# Technical Note: Response to Kirklees Council Highways

12 May 2022  
Version 1.0  
Issue

Fore Consulting Limited (Fore) has been commissioned by Keyland Developments to assist the preparation of an outline planning application (with all matters reserved) for employment development on land to the south of the former North Bierley Waste Water Treatment Works (WWTW), Bradford, in respect of transport and highways matters. This included the preparation of a Transport Assessment<sup>1</sup> submitted as part of a planning application to Kirklees Council (KC) and Bradford Metropolitan District Council (BMDC)<sup>2</sup>.

The purpose of this note is to provide a response to the comments received from Kirklees Council Highways Development Management (HDM) in relation to the Transport Assessment and Framework Travel Plan submitted as part of the outline planning application, dated 8 February 2022.

Figure Number:
 Figure 1

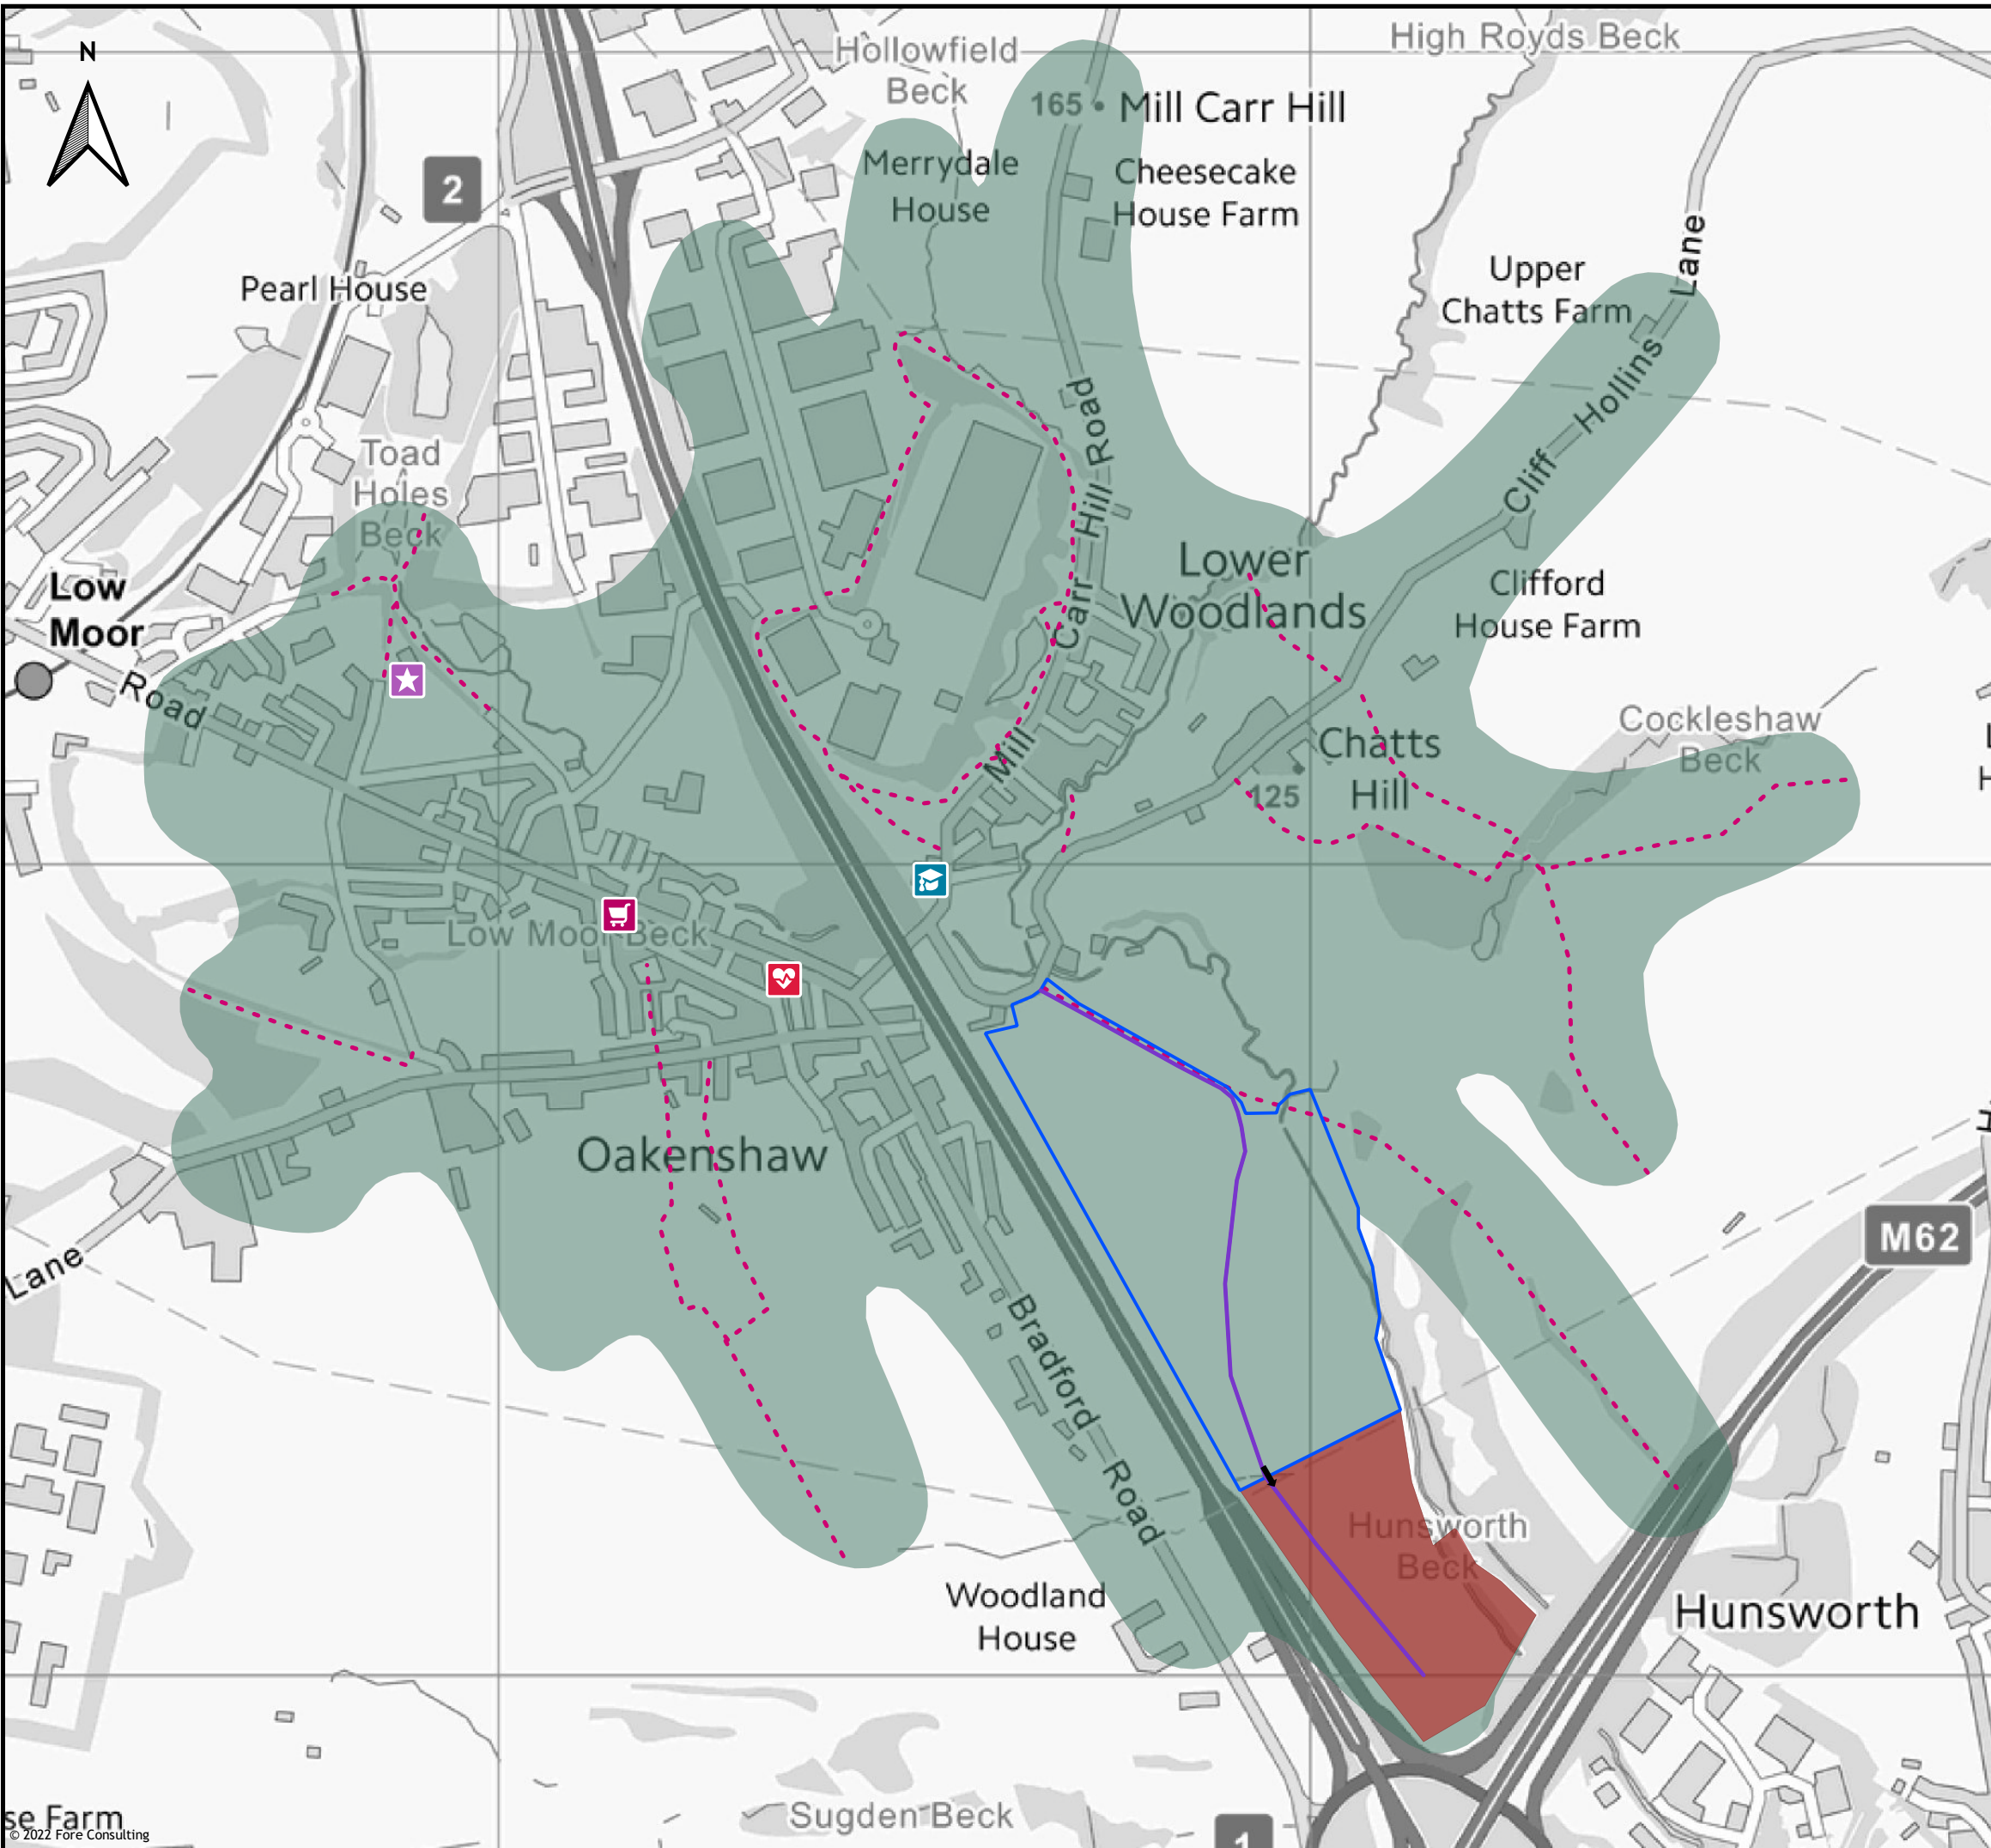
*Figure 2 should be updated to provide a more realistic pedestrian catchment. It is also recommended that the indicative development proposals are amended to ensure that pedestrian entrances are located to minimise walking distances and provide high quality links through the site and to the public highway.*

Revised figures in line with the above are appended to this note. The revised figures are not considered to change the assessment of the site as set out in the submitted TA; this is because the figures were measured from the indicative Phase 2 site access. Therefore, the site is accessible to the wider community on foot or by cycle, and options exist for future staff and visitors to travel to the site by sustainable modes. Both the indicative site access road for the Phase 1 and Phase 2 sites, and the indicative site access for the Phase 2 site are shown on the revised figures for further clarification.
